From: Anita Gardner <Anita.Gardner@arun.gov.uk>
Sent: 16 February 2021 12:00
To: Planning.Responses <Planning.Responses@arun.gov.uk>
Subject: FW: Planning Consultation on: CM/53/20/PL

Engineers Comments Regarding Surface Water Drainage

SITE PLAN
SCALE 1:500 @ a3

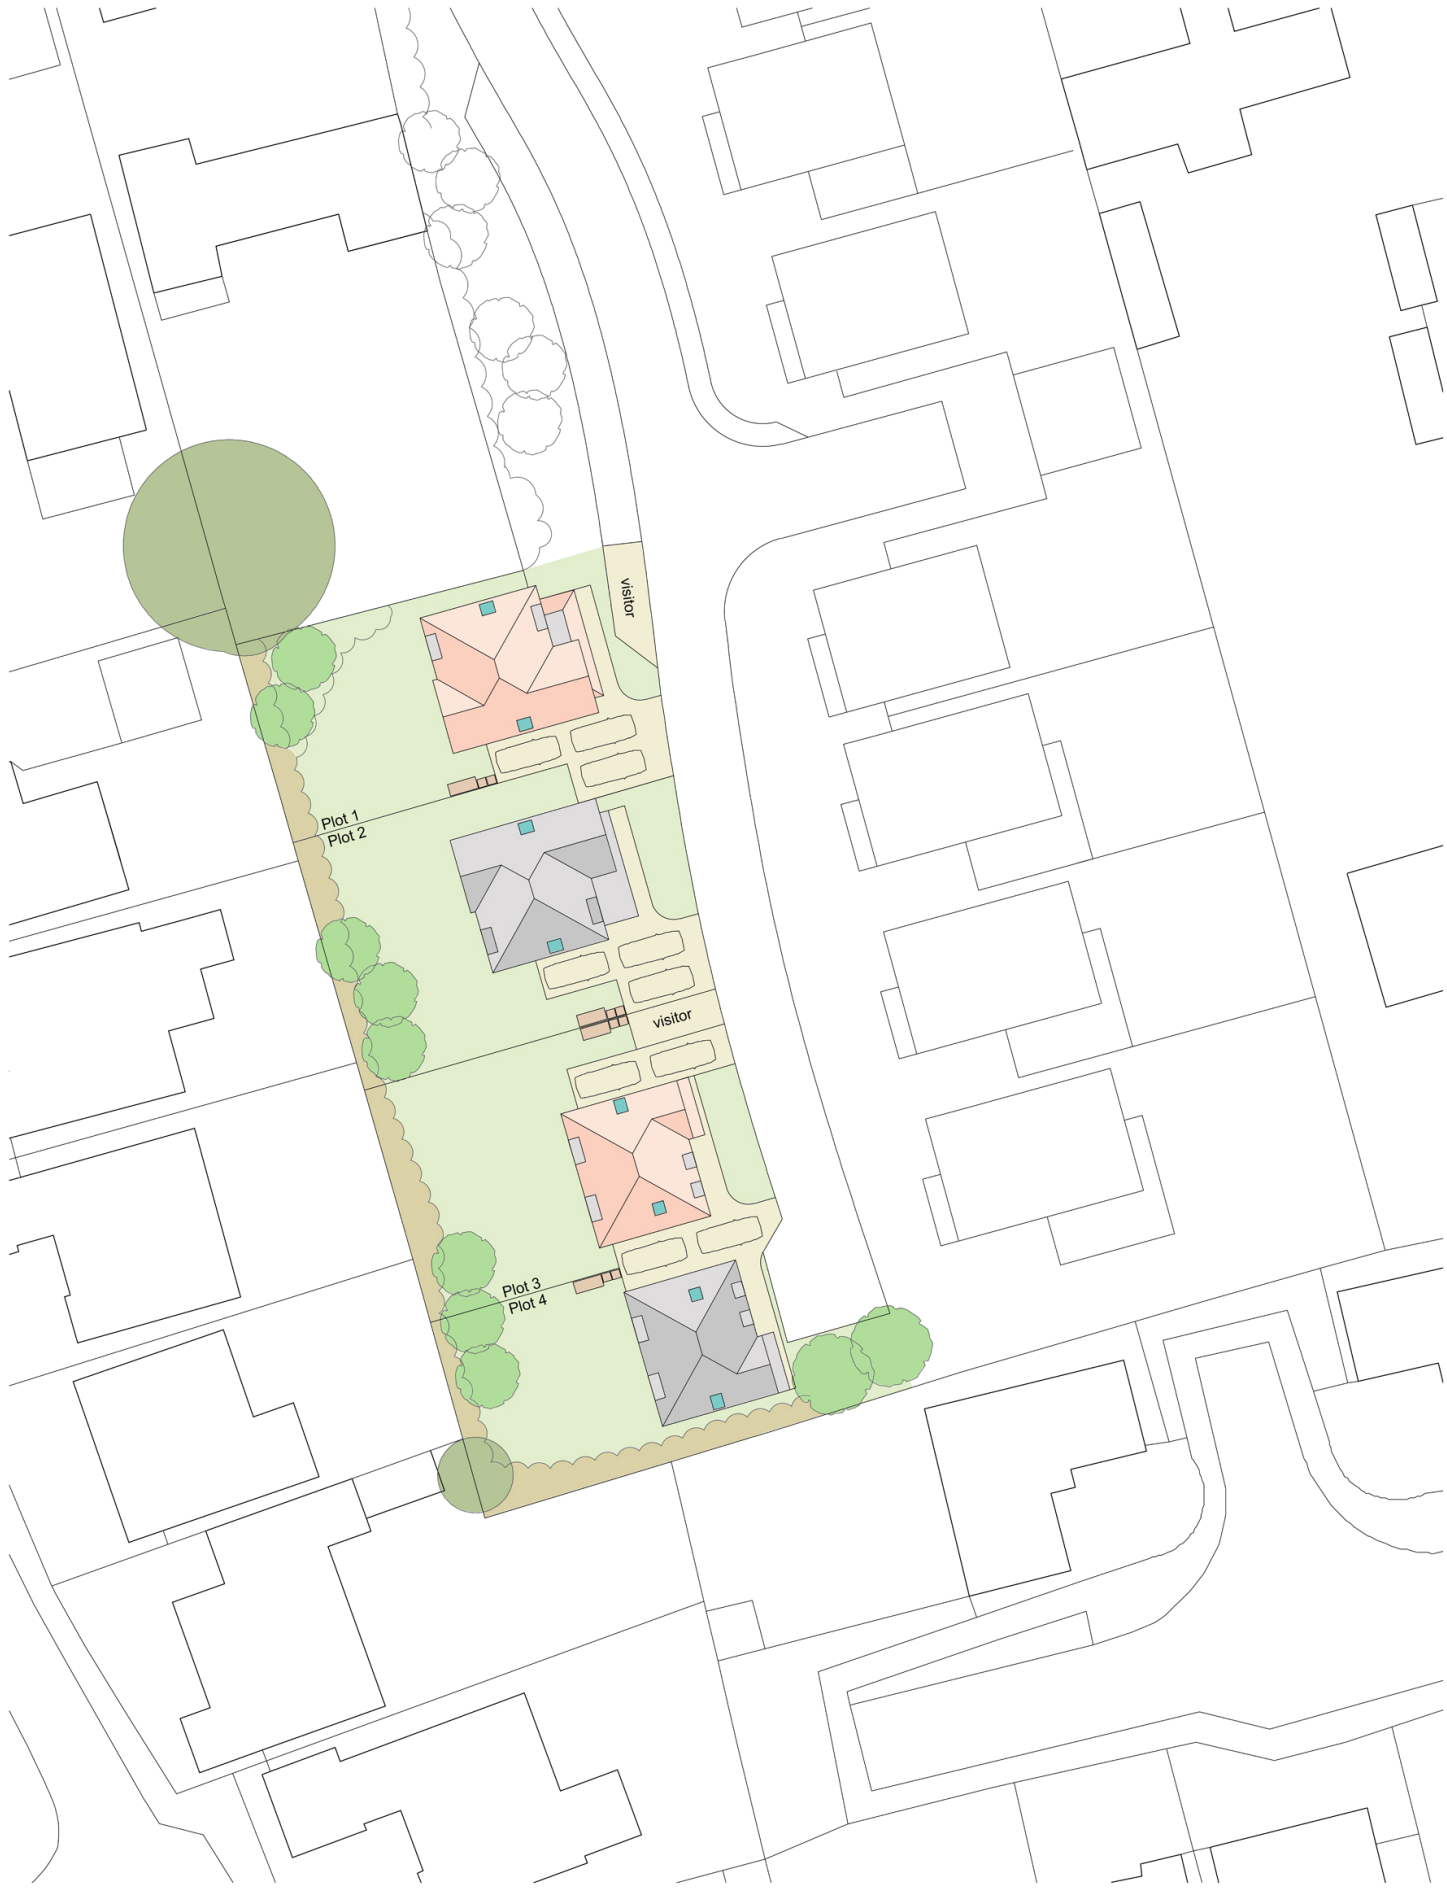
Ground investigation results from neighbouring sites evidence that infiltration is highly unlikely to be suitable at this location due to the presence of high groundwater (0.3mbgl). Therefore, a connection to the watercourse along Horsemere Green Lane is likely to be required. It is unclear how this will be possible as the site is land locked and the shallow falls across the site to the watercourse. We note that the site access is via the proposed development at Scyld. We would therefore suggest that the two sites will require a drainage scheme that works together, however the drainage scheme for Scyld as it currently stands would not have capacity to drain any additional water.

To overcome our holding objection we request that the applicant submits details of how they propose to drain the site in a worst case/no infiltration scenario. If this information is not provided prior to determination it is likely that the layout will unduly bias the design of surface water drainage and could result in flooding being increased elsewhere.
